From: Anita Gardner <Anita.Gardner@arun.gov.uk>
Sent: 21 April 2021 16:07
To: Planning.Responses <Planning.Responses@arun.gov.uk>
Subject: FW: K/15/21/DOC Spring Tide, Gorse Avenue

From: Anita Gardner
Sent: 21 April 2021 16:06
Subject: K/15/21/DOC Spring Tide, Gorse Avenue

I refer to the above application.

Drawing: DOC - Materials
ST - OBA - 00 - ZZ - DR - A - 0450 -
Status: Discharge Of Conditions OBA proj no: 247

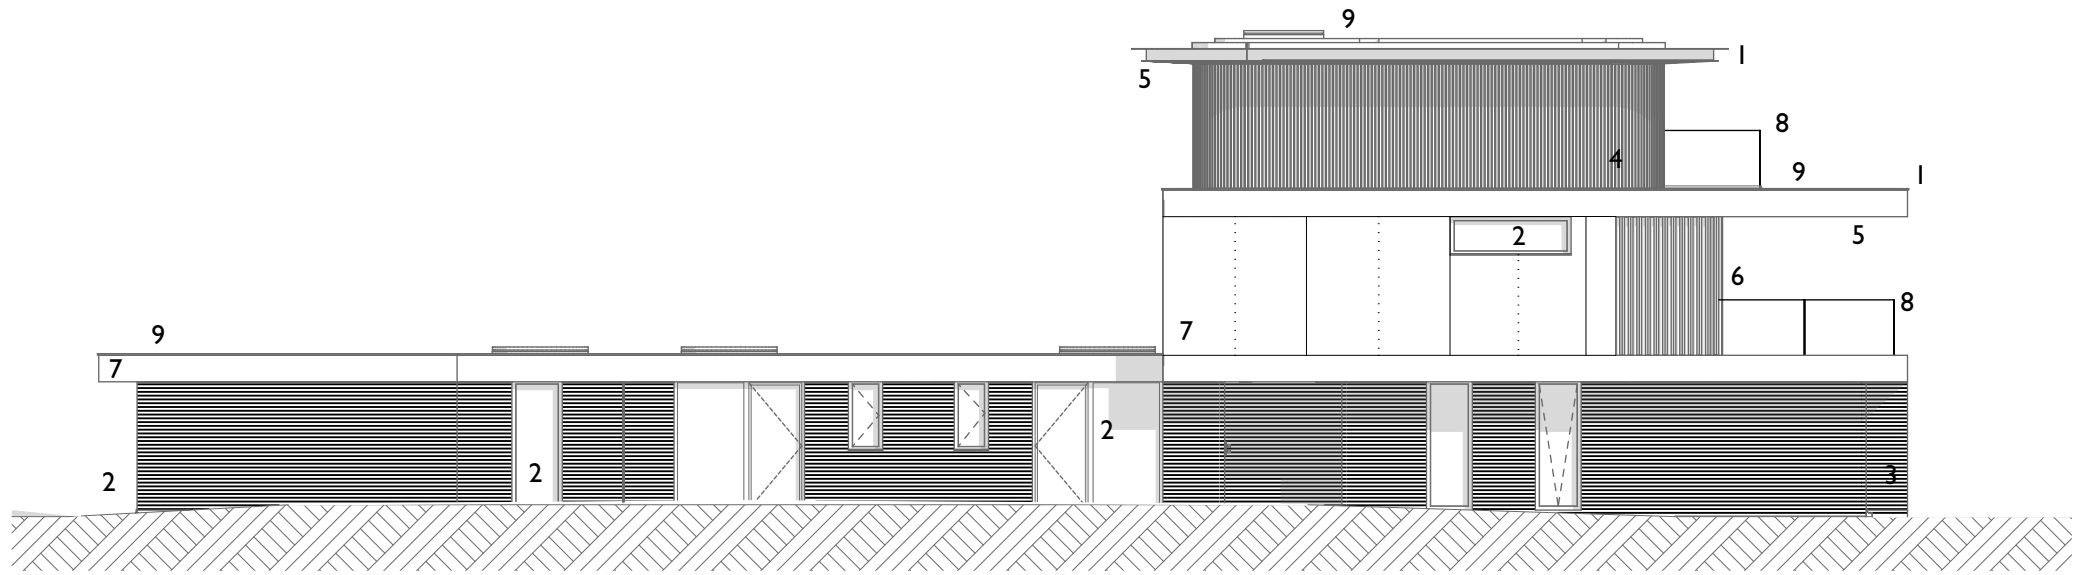
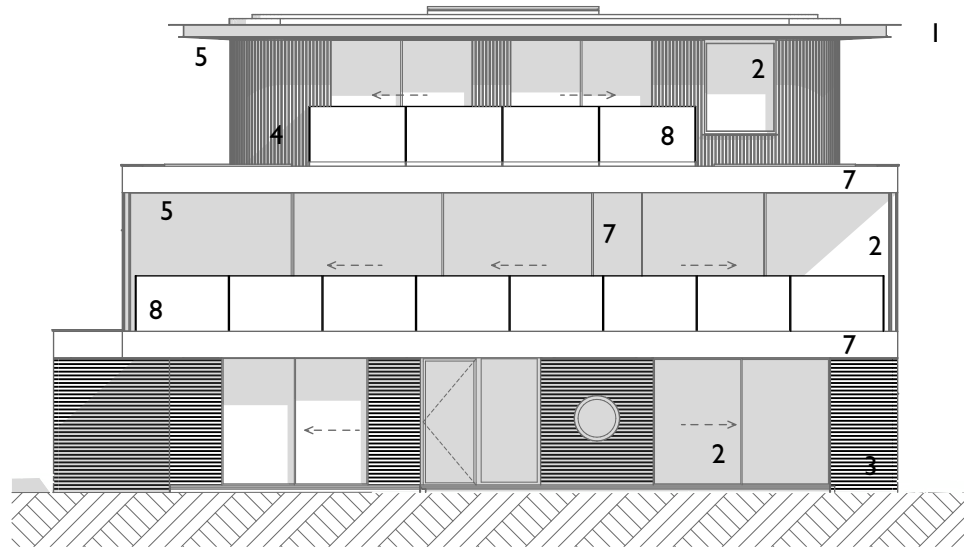
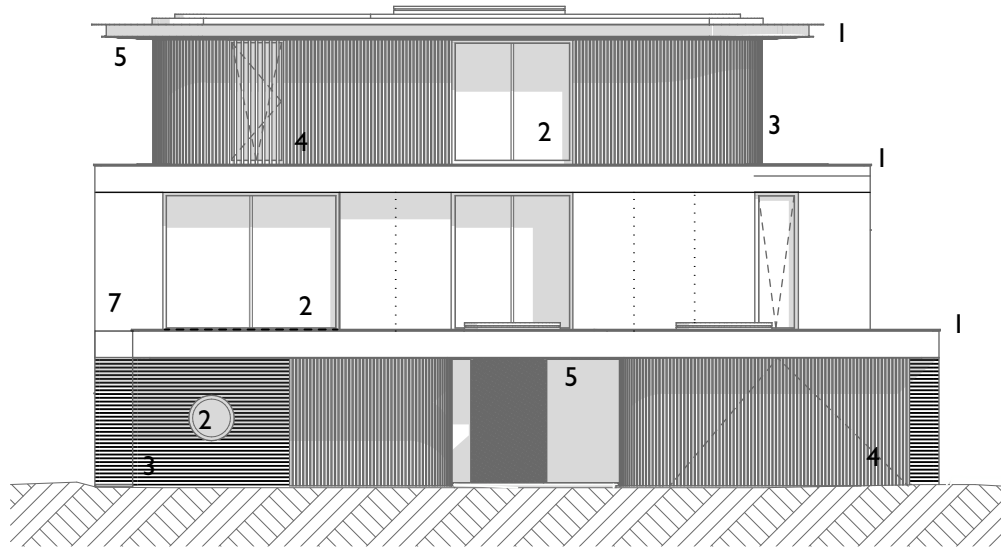
I note that the elevation design of the building you have submitted annotated with materials is different from that approved under K/40/18/PL. I cannot therefore consider the application in its current form. You will either need to withdraw the application and pursue the amended design by way of submission of an application to vary the plans condition and then submit details of materials in a new DOC application or submit the material details requested for approval on the approved elevation drawings or within a schedule which can be substituted for the details submitted.
